From: Martyn White
Sent: 05 October 2018 12:04
To: Planning.Responses
Cc: Simon Davis
Subject: AW/198/18/PL

AW/198/18/PL

The proposed dwelling is located within the Craigweil House Conservation Area.

DRAWING TITLE
Site Plan, Block Plan and Location Plan

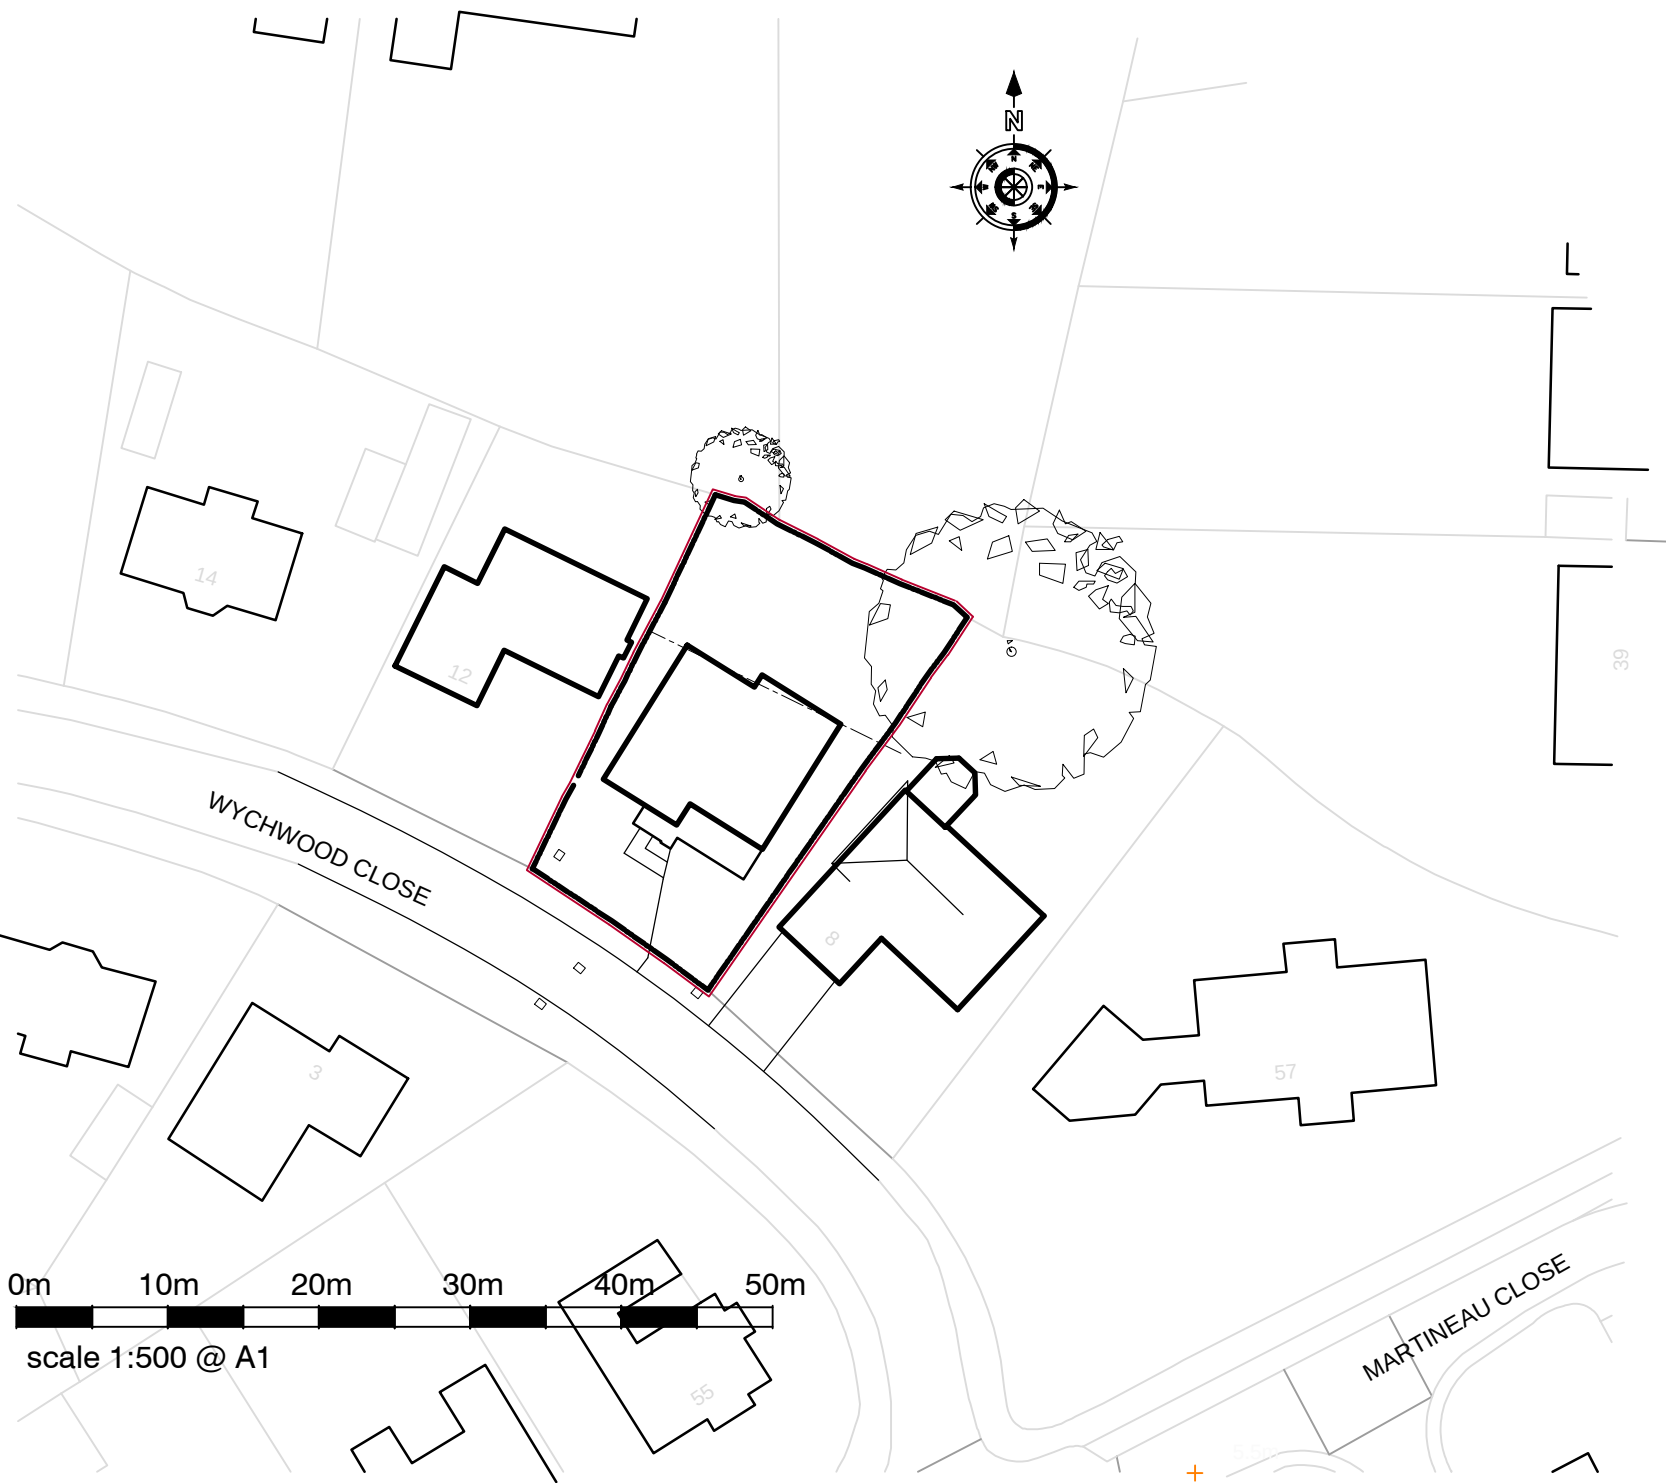
The application also includes a cross over from the highway to the site, and details regarding the paving materials to be used should be provided.

DRAWING TITLE
Proposed Plans and Elevations

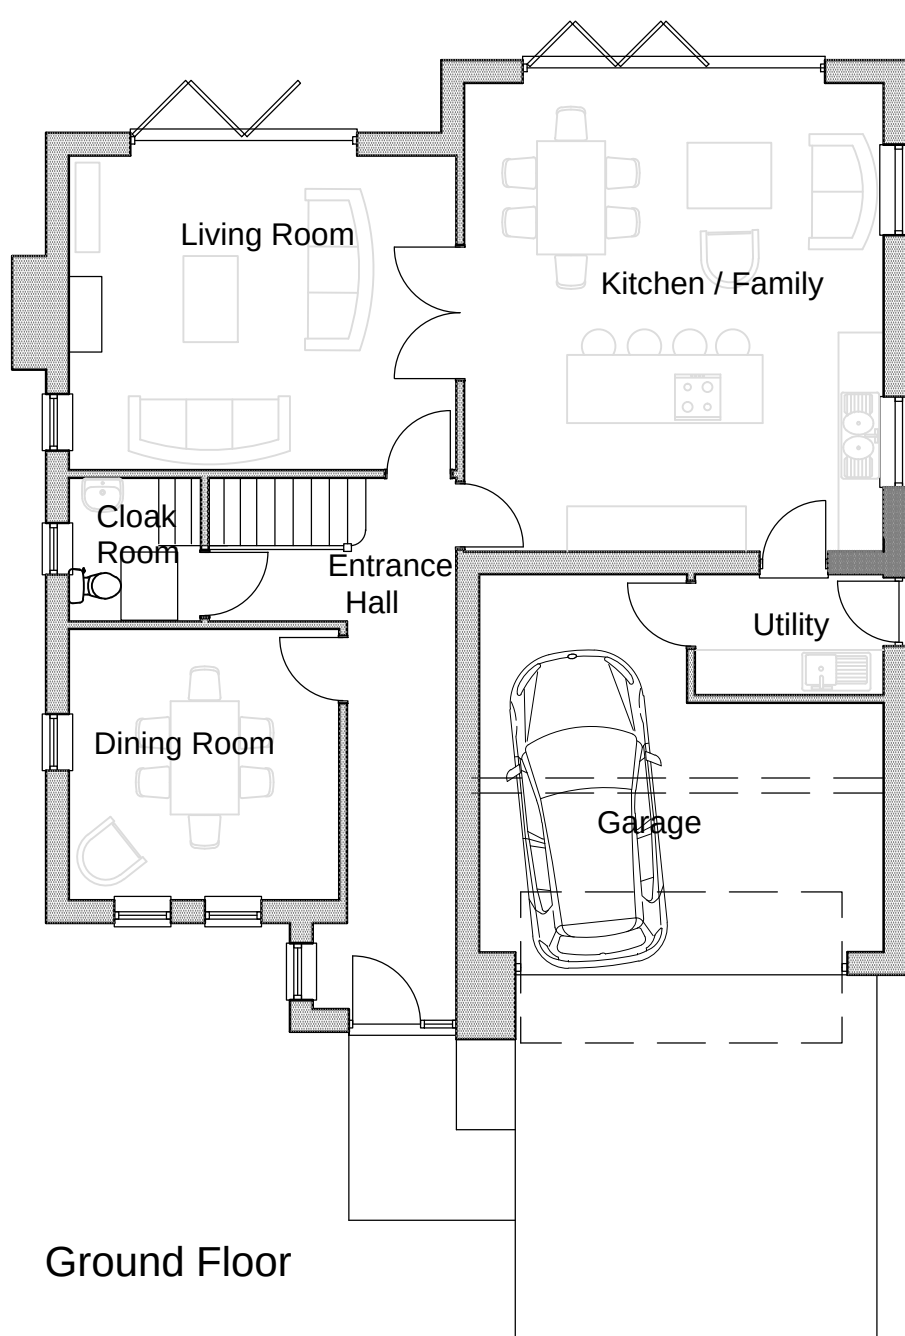
The proposed dwelling aims to recreate elements of dwellings from the 1930's. Elements such as the form of the building, and the design and shape of the windows reflect this aesthetic, and can be supported, subject to the approval of details. The overall design of the building is modern in nature, but this shouldn't be considered harmful to the established character of the area.

I do have some concerns regarding the use of Cedral boarding, but this may be acceptable depending on the colour/appearance proposed. Maybe this can be confirmed?
